**DEVIATION REVIEW
 AND DECISION FORM**

**Deviation No. 1
 REV 2-8-19**

Subdivision or Project Name: Rollin' Ridge

Section of ECM from Which Deviation is Sought: 2.3.2 Design Standards by Functional Classification

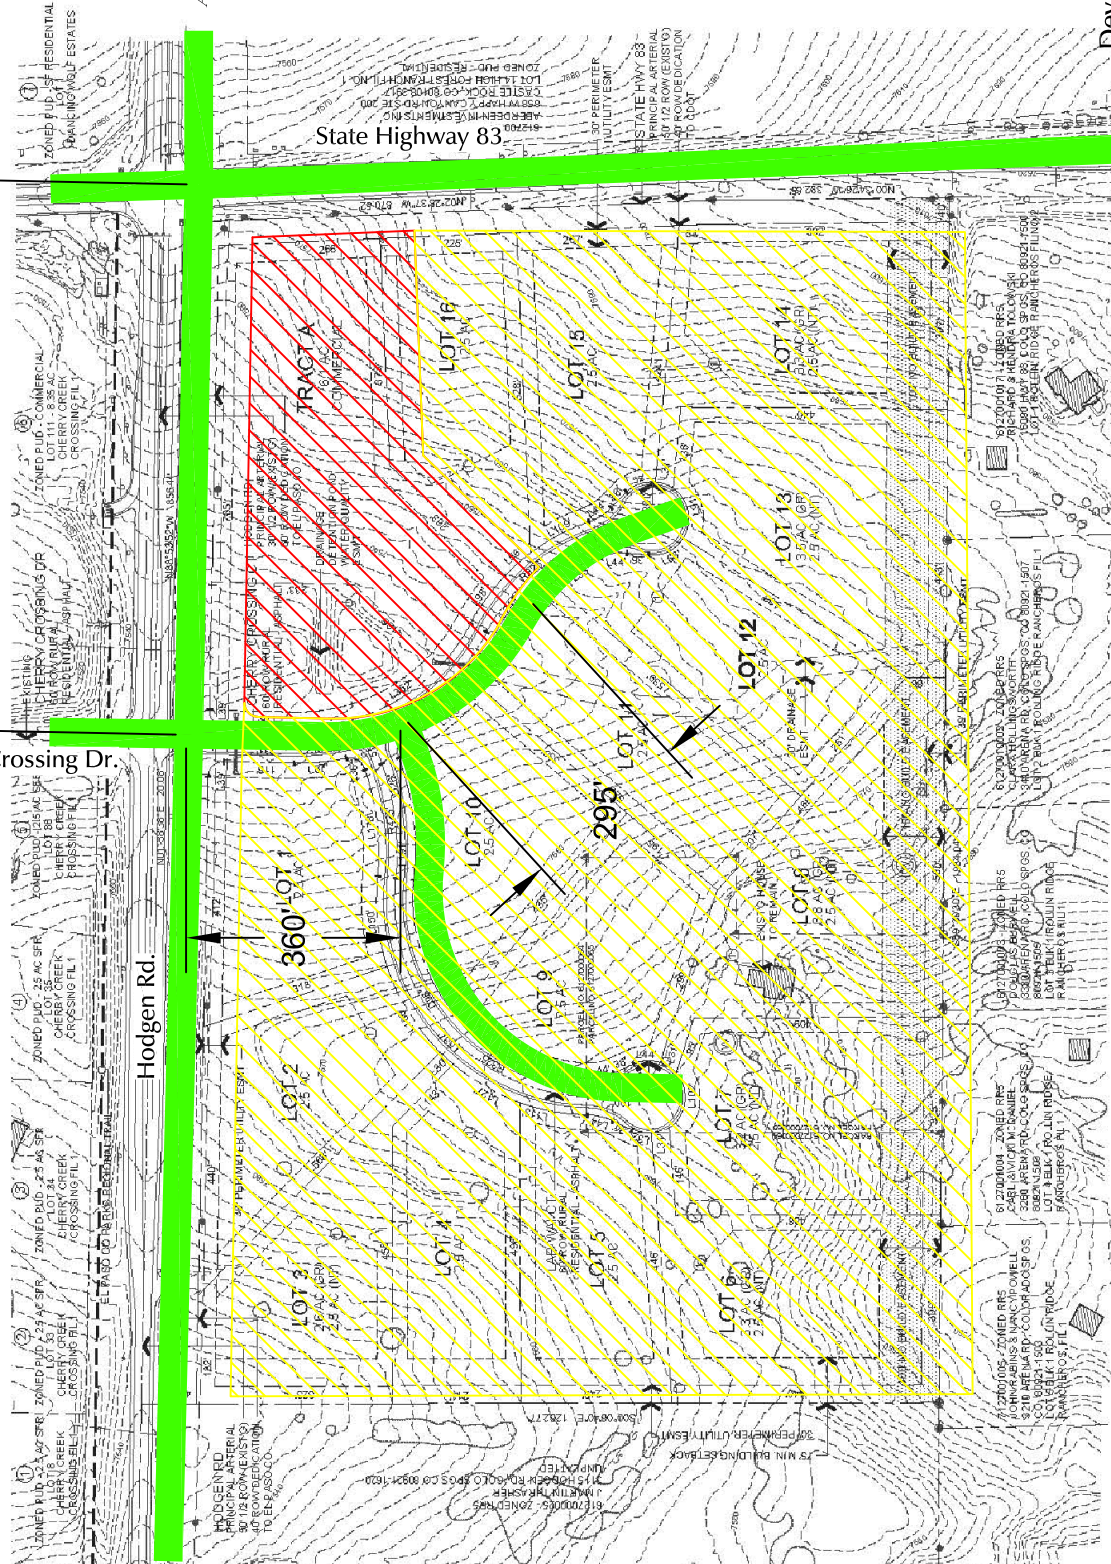
remove reference to intersection spacing, it is in deviation 2.
 This should be the only deviation with the turning movement exhibit (because of the narrower shoulder).
 Lane width should be discussed for clarification.
 Ditto comment on exhibits as stated in deviation 2.
 A

remove all reference to intersection spacing please.
